SYDNEY BUSINESS PARK STAGE 3 FACILITIES (SSD-10477) – SECTION 4.55 MODIFICATION (MOD 3) – ADDITIONAL INFORMATION

Marsden Park Developments Pty Ltd (Sydney Business Park) is proposing to modify the development consent for the Stage 3 Facilities Project (the project) in Sydney Business Park (SSD-10477), within the Marsden Park Industrial Precinct in Western Sydney.

The proposed modification is outlined in the Modification Report prepared by PJEP Environmental Planning Pty Ltd (PJEP) dated 28 September 2022, and involves minor changes to Warehouse 2.

1220027_ A2101

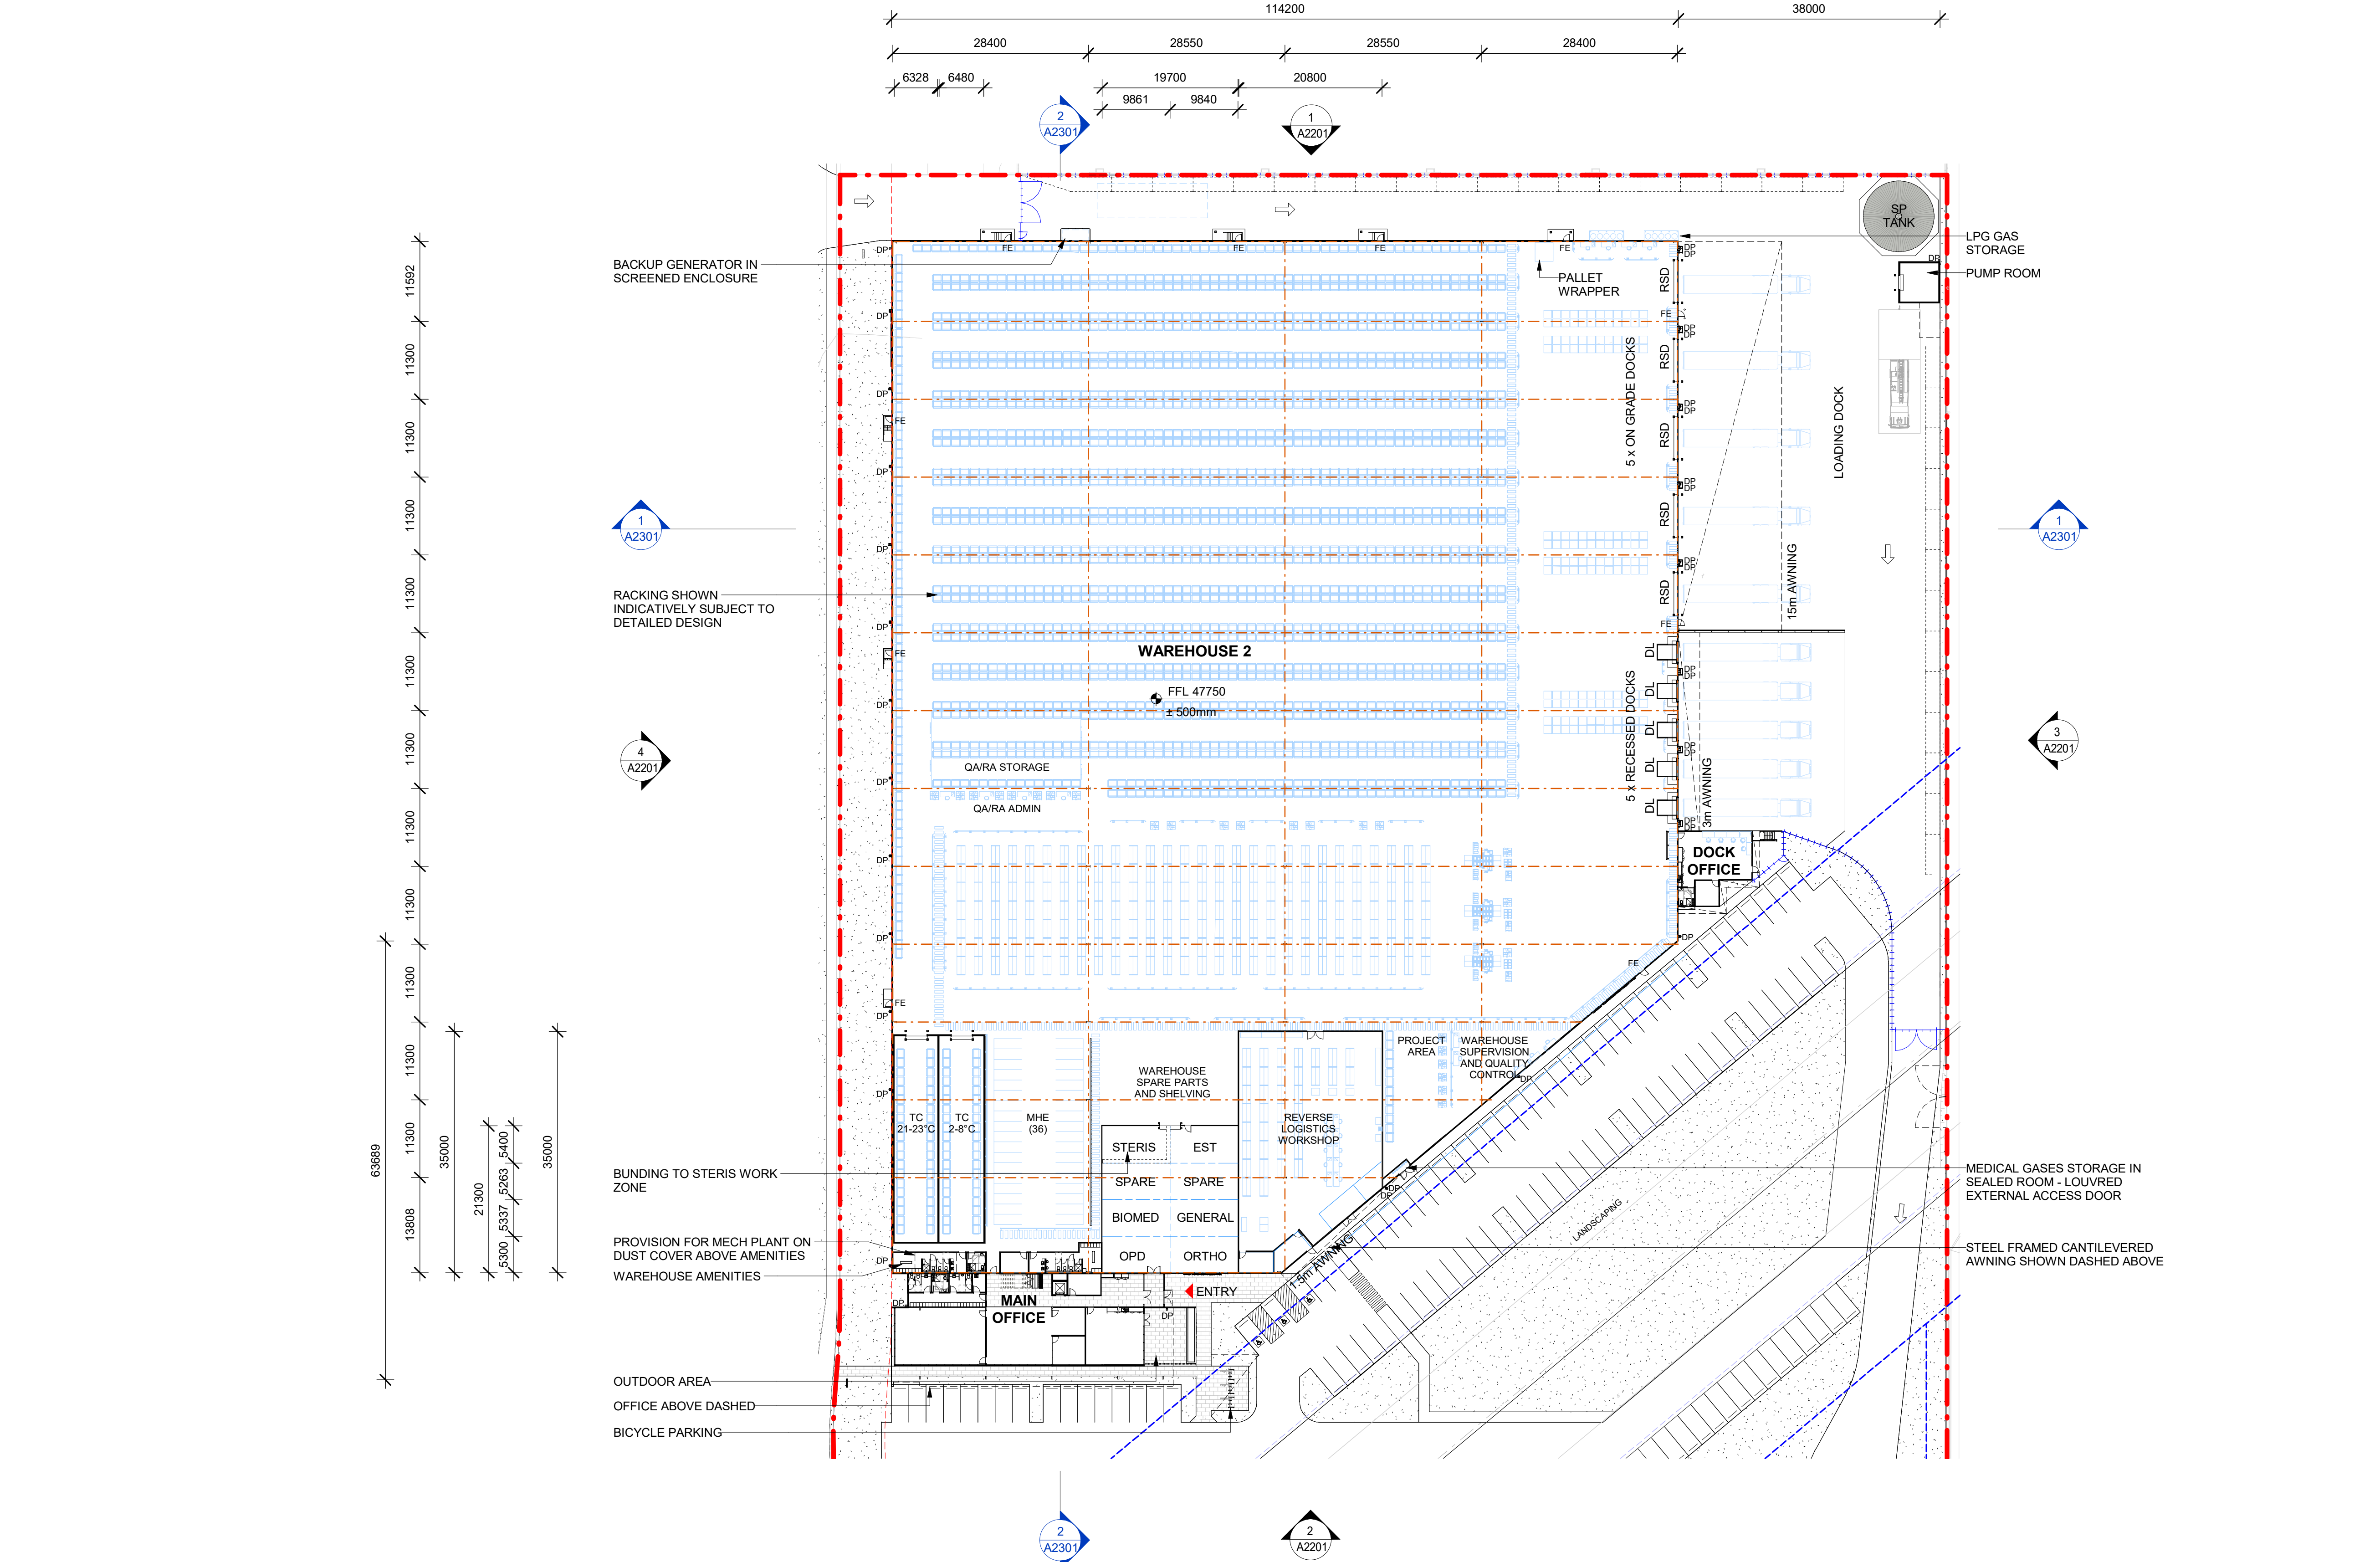
As indicated on the architectural plans, the generator has been located in the north-western area of the site well away from the Ingenia caravan park. The back-up generator would have a nominal power capacity of approximately 300-350kW based on a 6 cylinder diesel engine. Air emissions when in use would be similar to those of an idling light truck. Consequently, intermittent use of the generator is not expected to result in any significant air emissions, and a specialist air quality assessment is not considered necessary or warranted for the proposal.
